File No: SSD 9275  
Our Ref: R/2018/27

**State Significant Development SSD 9275 – Student Accommodation – 80-88  
Regent Street, Sydney**

## ATTACHMENT A

Elevation West

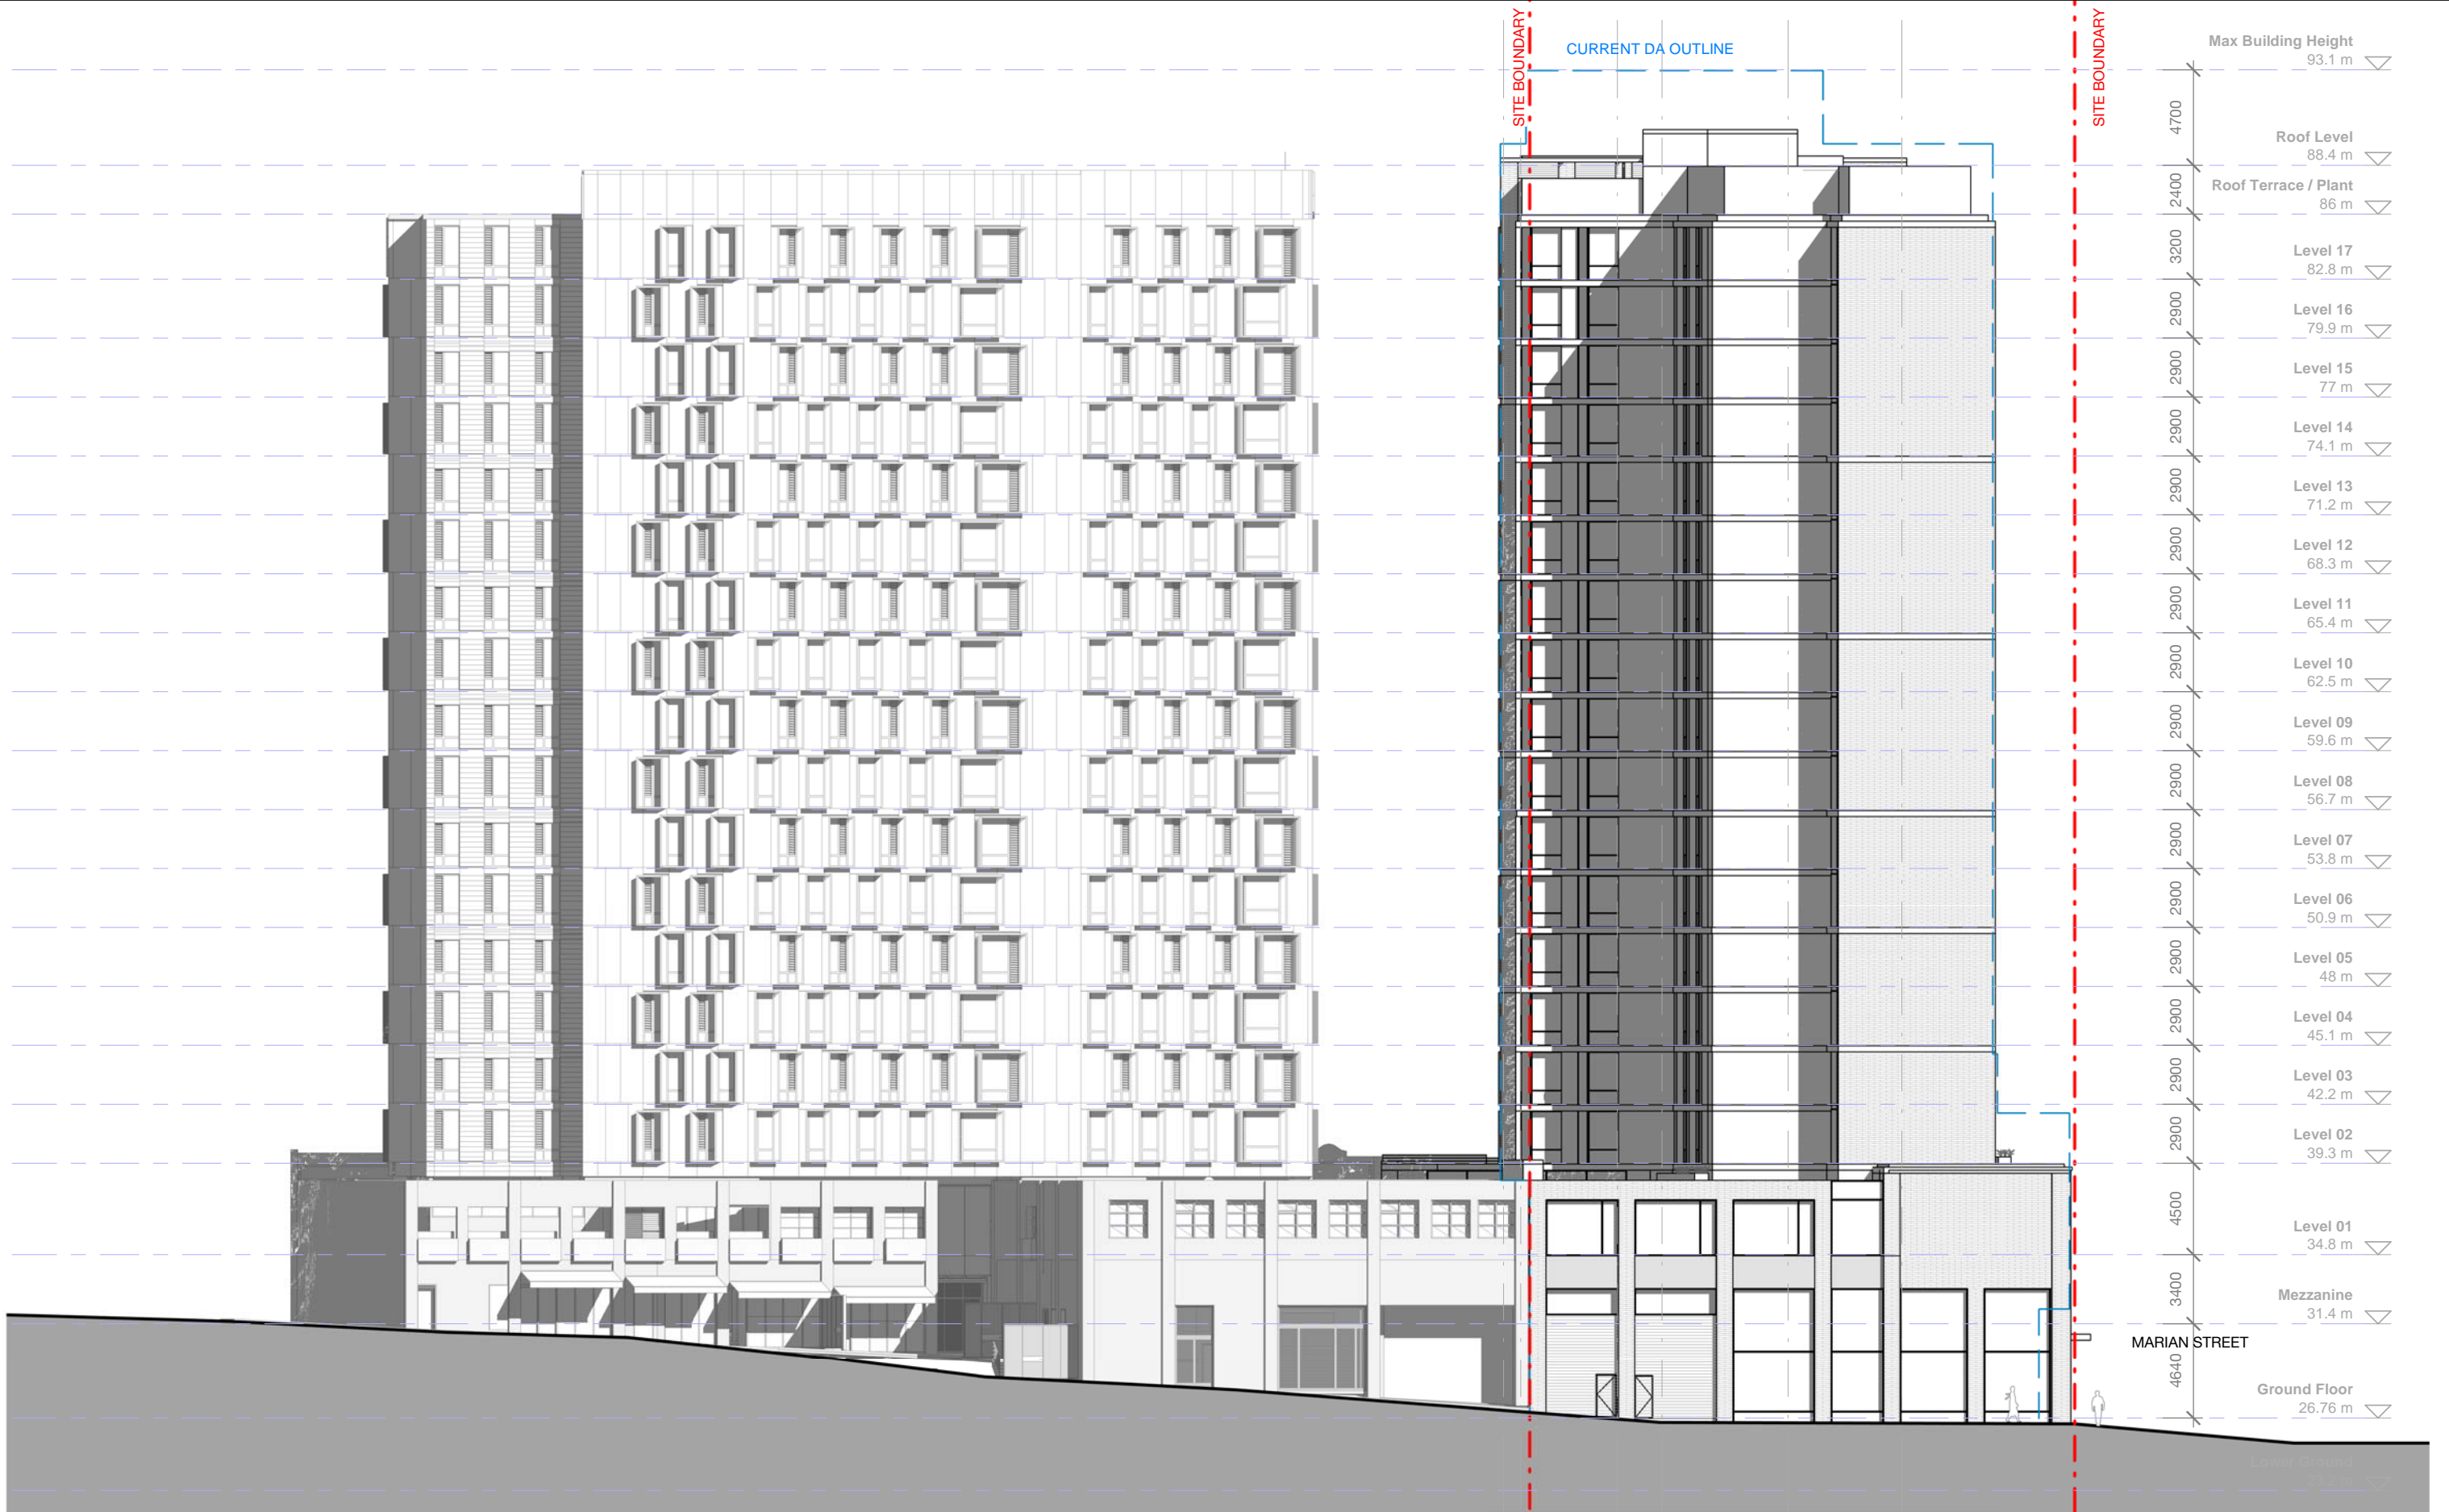
The west elevation to William Lane is substantially composed of blank facades. As this elevation addresses habitable rooms in the development to the west (bedrooms and living rooms / balconies), consideration should be given to providing visually interesting and finely detailed elevations (which may perhaps include surface modulation or other articulation to relieve the flatness of the surface). The elevation drawings do not notate the intended material or finish for part of the facade.
